Subject: RE: Planning Consultation on: CM/53/20/PL

Engineers Comments Regarding Surface Water Drainage

Site Address: Land at Wren Cottage Horsemere Green Lane Climping BN17 5QZ

Description of Works: Development of 2 No 2-bed & 2 No 3-bed detached dwellings & associated works. This site is in CIL Zone 3 and is CIL Liable as new dwellings.

SITE PLAN
SCALE 1:500 @ a3

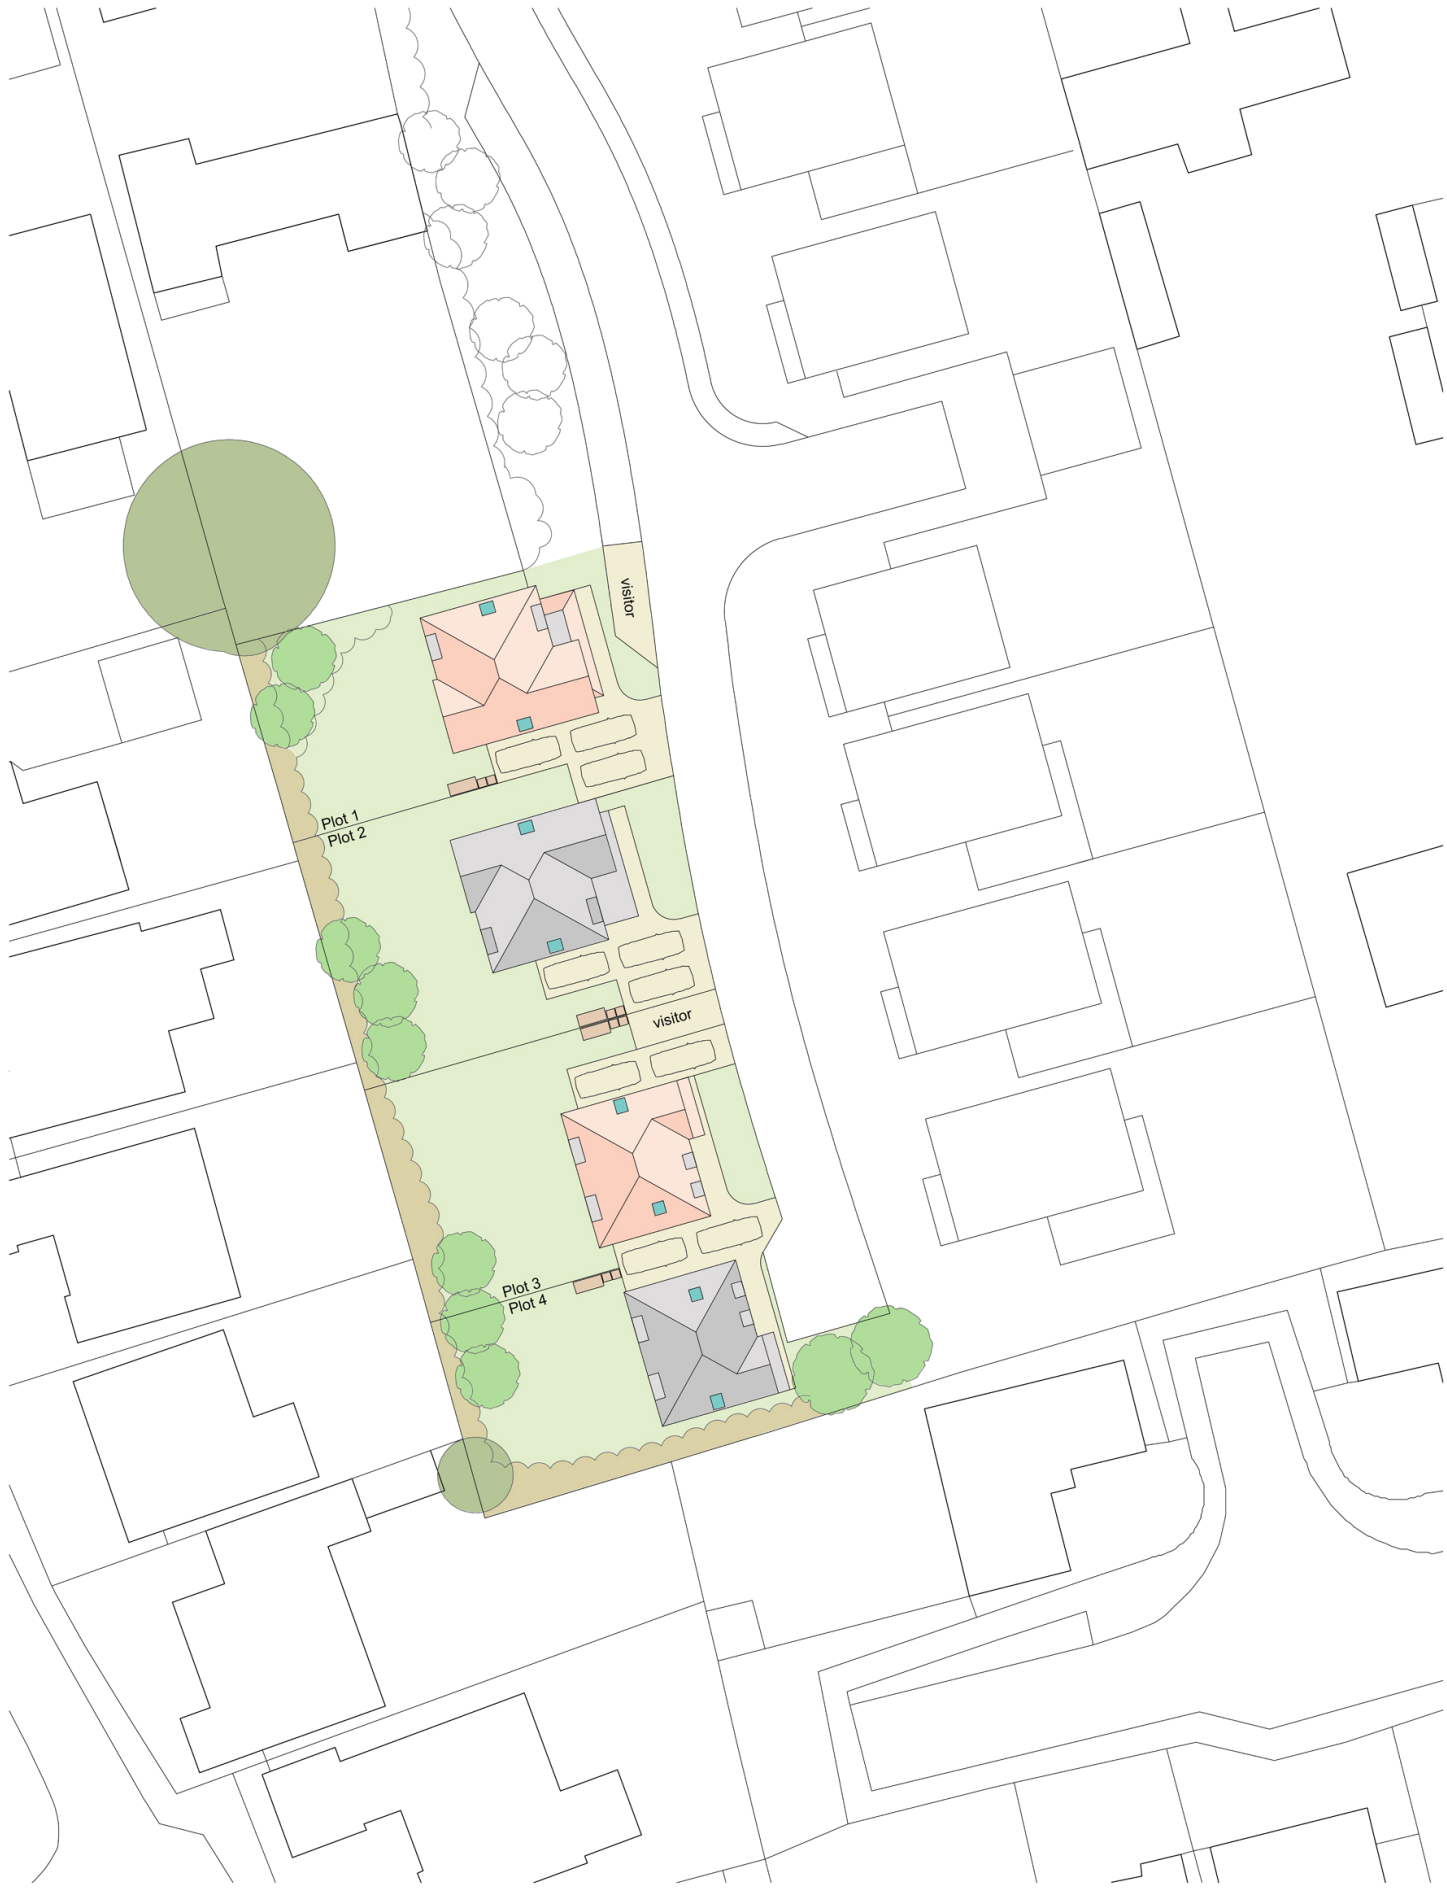
At this stage no serious consideration has been given as to how to drain surface water from the site. Within the Flooding and Drainage Statement the applicant states that they are happy for this to be dealt with via condition, understanding the necessity for winter groundwater monitoring and infiltration testing. The applicant expects to drain the site via soakaways in the property gardens, or in shallow soakaways and permeable paving if groundwater is evidenced at shallow depth.

Ground investigation results from neighbouring sites evidence that infiltration is highly unlikely to be suitable at this location due to the presence of high groundwater (0.3mbgl). Therefore, a connection to the watercourse along Horsemere Green Lane is likely to be required. It is unclear how this will be possible as the site is land locked and the shallow falls across the site to the watercourse. We note that the site access is via the proposed development at Scyld. We would therefore suggest that the two sites will require a drainage scheme that works together, however the drainage scheme for Scyld as it currently stands would not have capacity to drain any additional water.

Therefore I wish to lodge a holding objection to this application.

To overcome our holding objection we request that the applicant submits details of how they propose to drain the site in a worst case/no infiltration scenario. If this information is not provided prior to determination it is likely that the layout will unduly bias the design of surface water drainage and could result in flooding being increased elsewhere.

“Development shall not commence, other than works of site survey and investigation, until full details of the proposed surface water drainage scheme have been submitted to and approved in writing by the Local Planning Authority. The design should follow the hierarchy of preference for different types of surface water drainage disposal systems as set out in Approved Document H of the Building Regulations, and the recommendations of the SuDS Manual produced by CIRIA. Winter groundwater monitoring to establish highest annual ground water levels and winter Percolation testing to BRE 365, or similar approved, will be required to support the design of any Infiltration drainage. No building / No part of the extended building shall be occupied until the complete surface water drainage system serving the property has been implemented in accordance with the agreed details and the details so agreed shall be maintained in good working order in perpetuity.”
